# EPC DPW Stormwater\_2026-06-10\_003 - PCM Applicability Form Markup Summary

PPR2615

OFFSITE OVERALL STORM PLAN

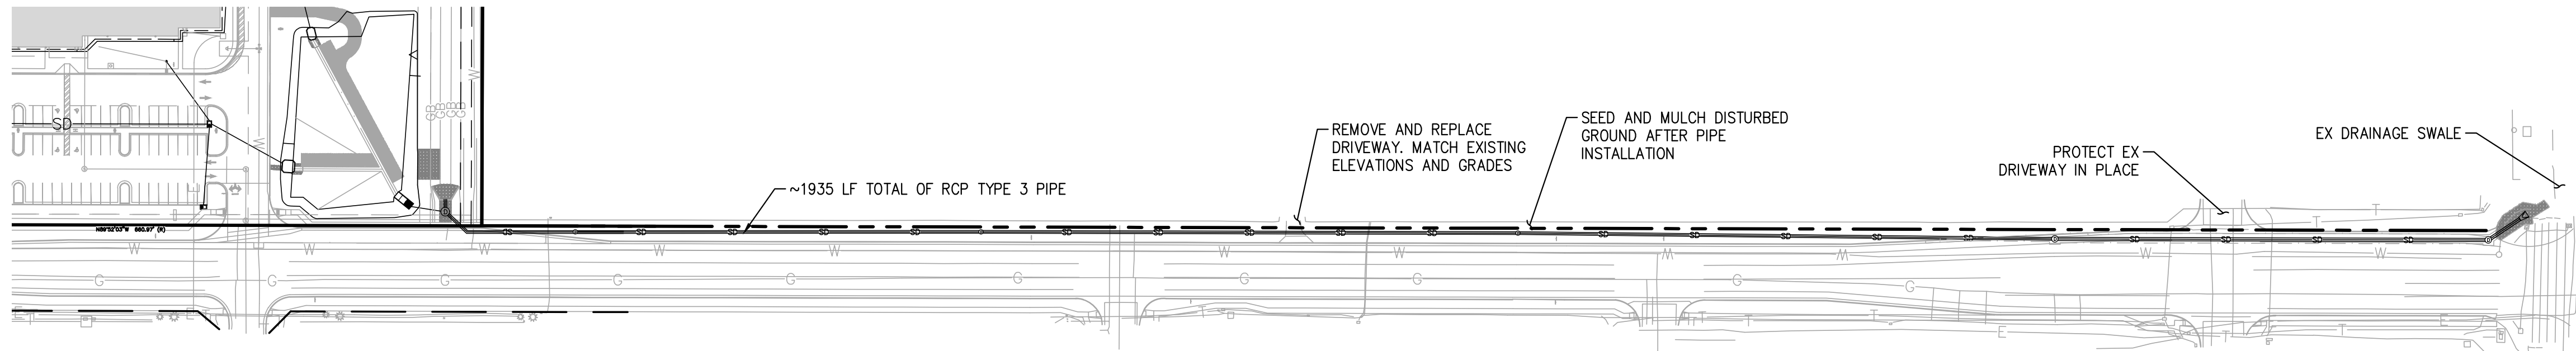
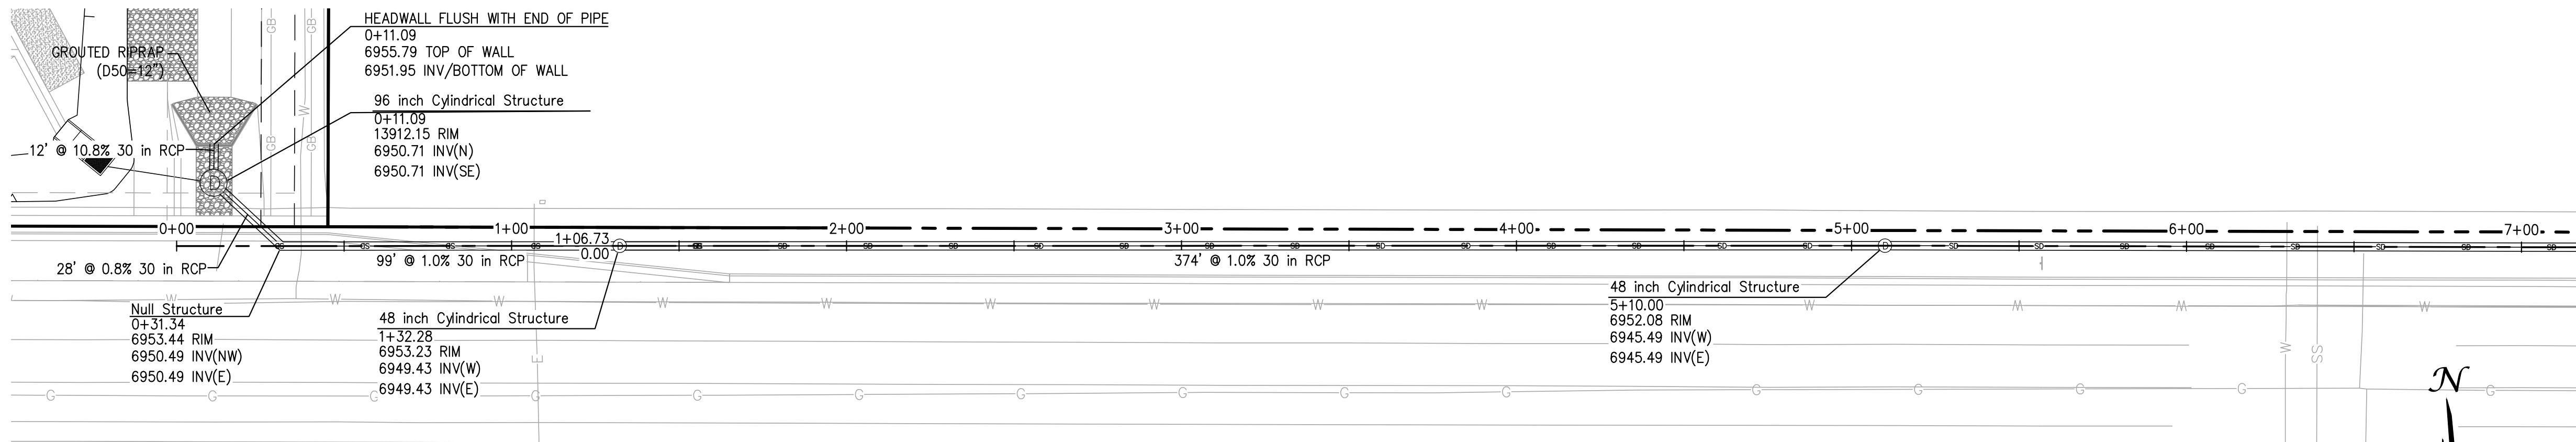
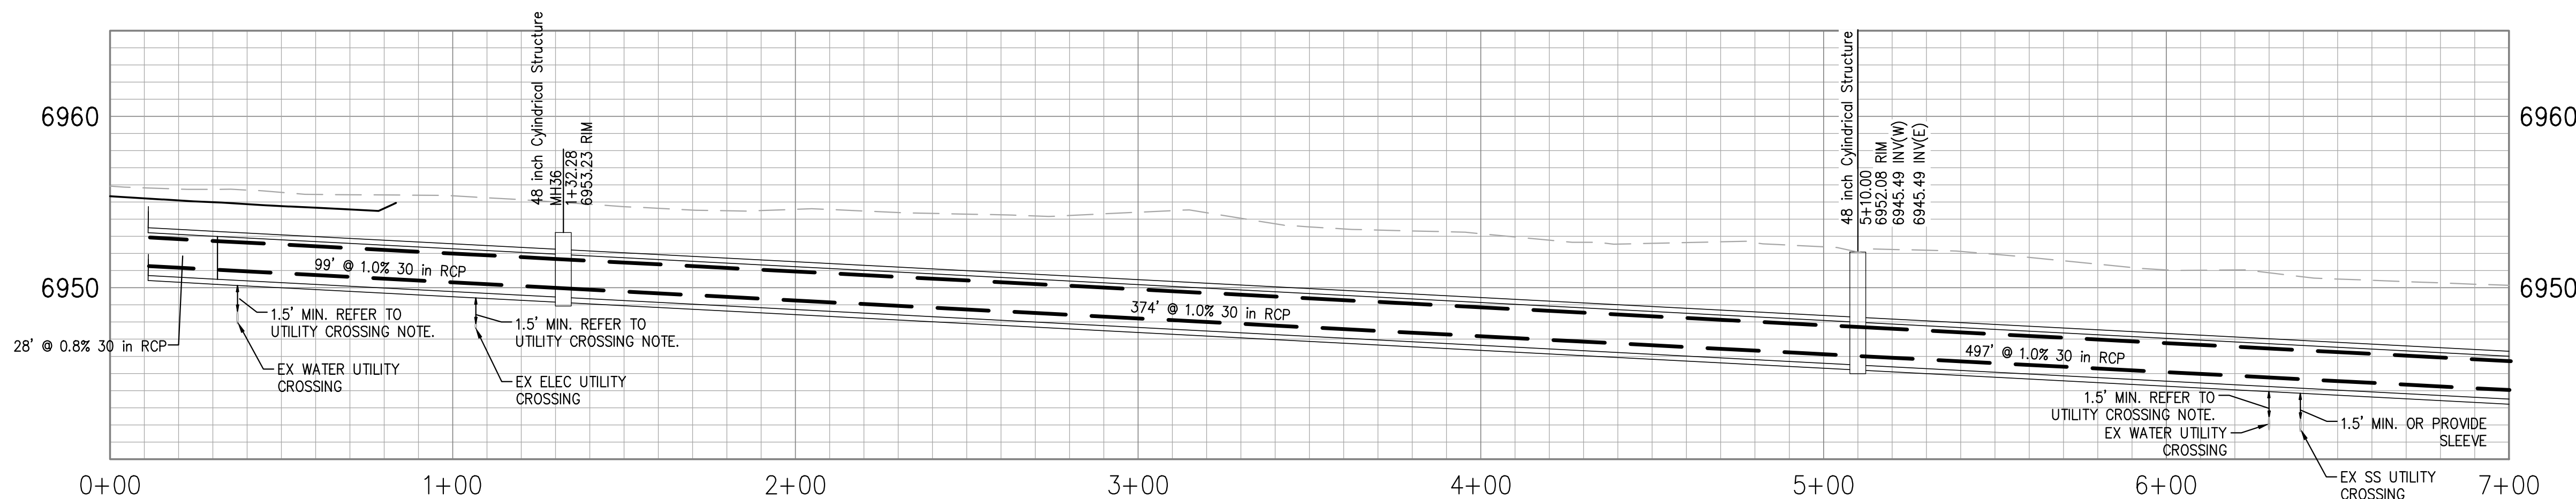
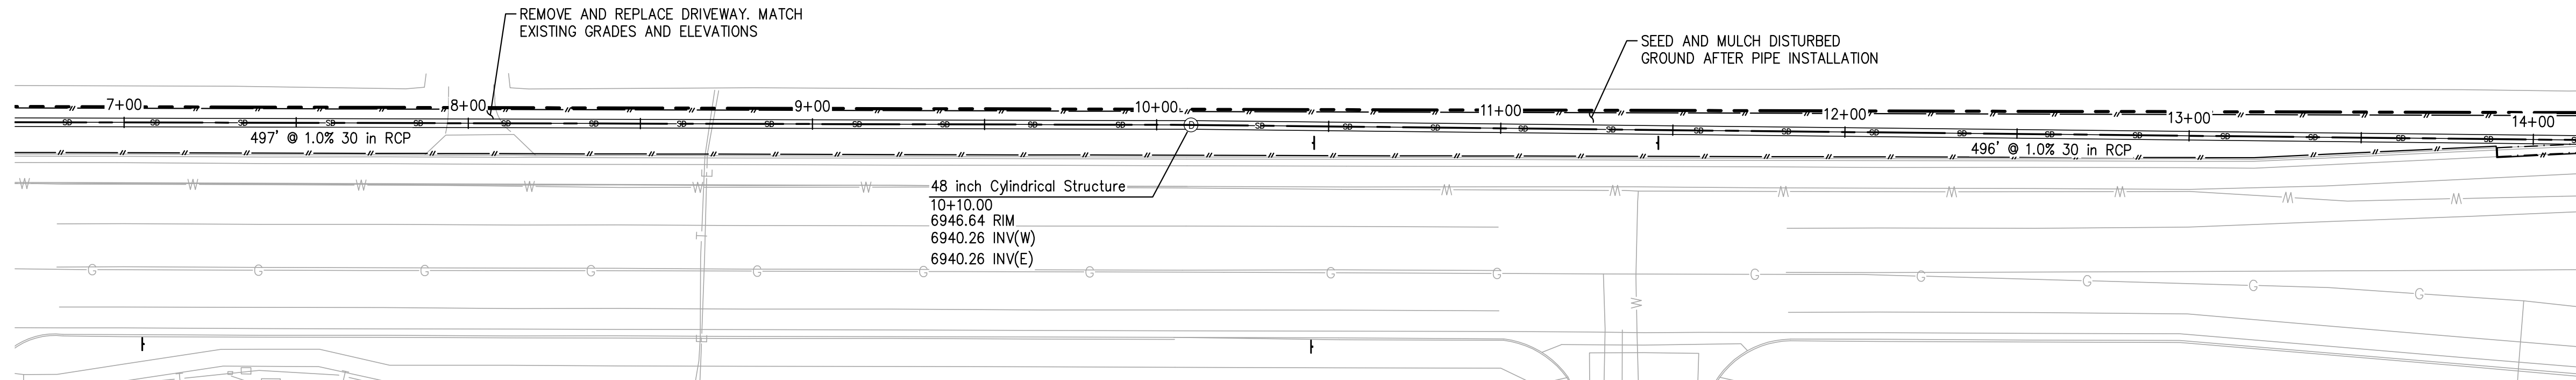
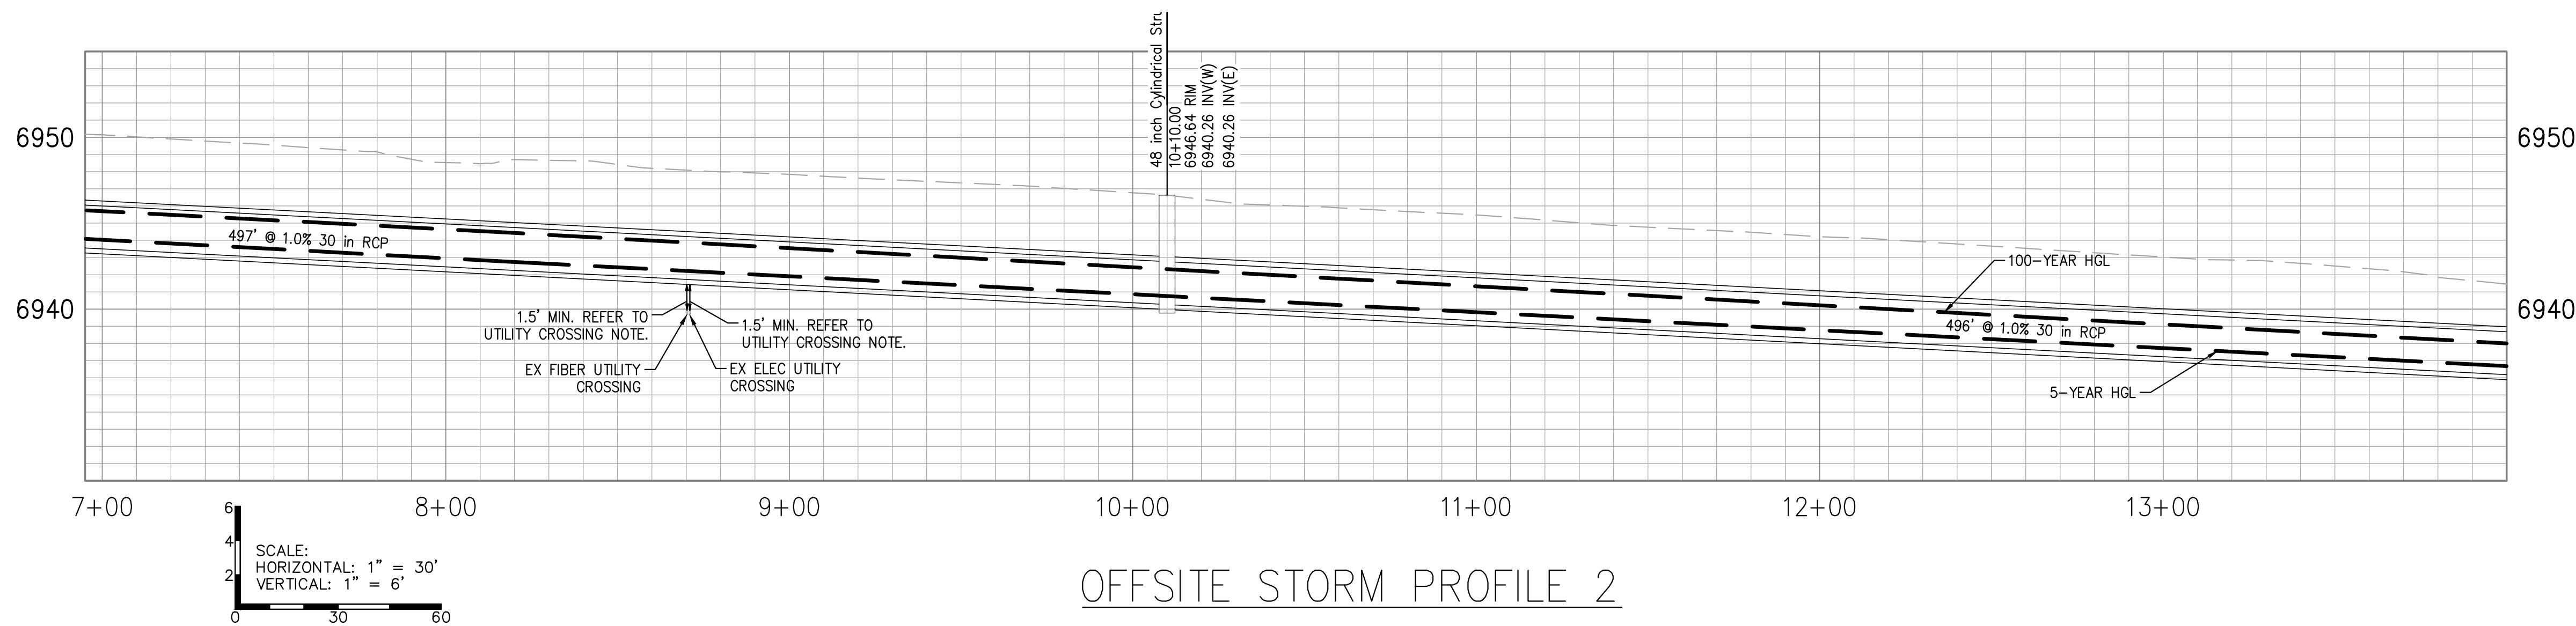
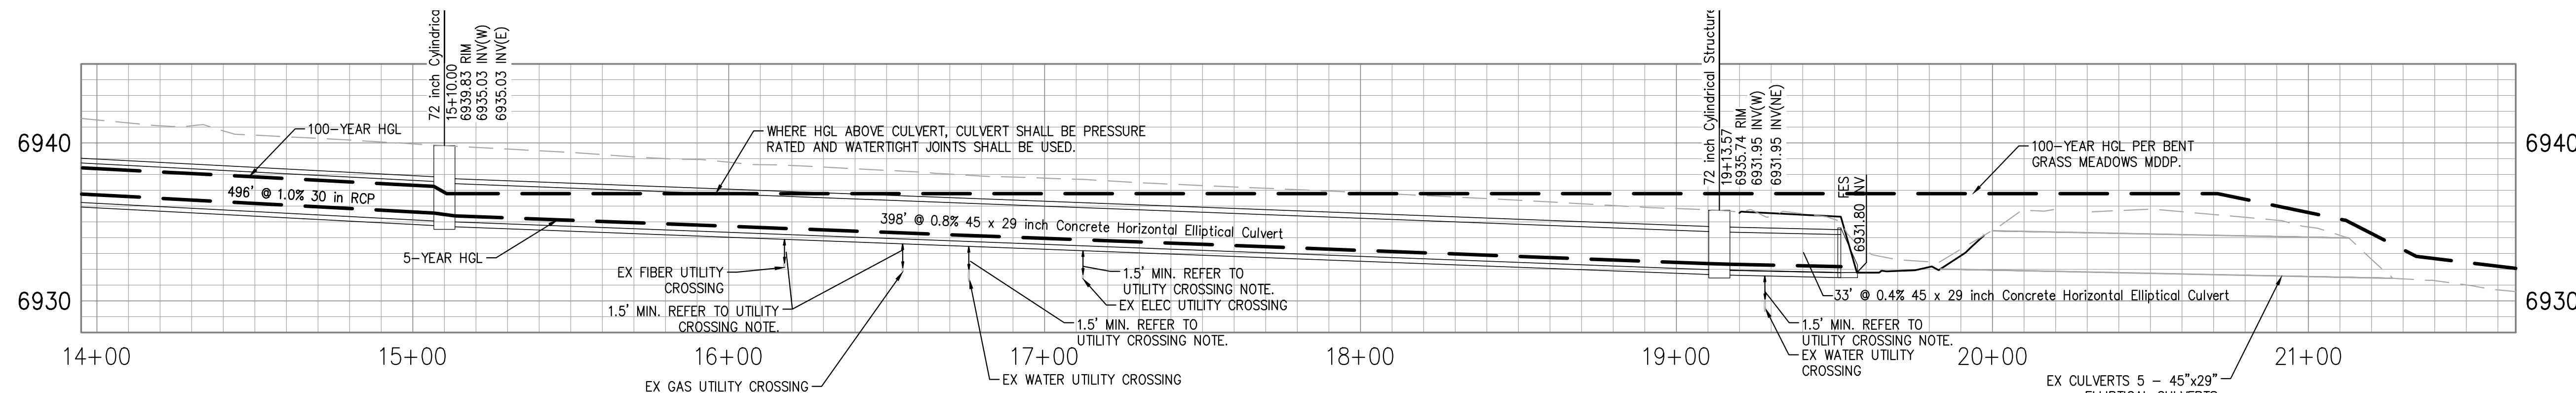
One of these exclusions may be applicable for the disturbance related to the off-site storm drain installation

RESPONSE: FORM UPDATED TO INDICATE APPLICABLE EXCLUSIONS.
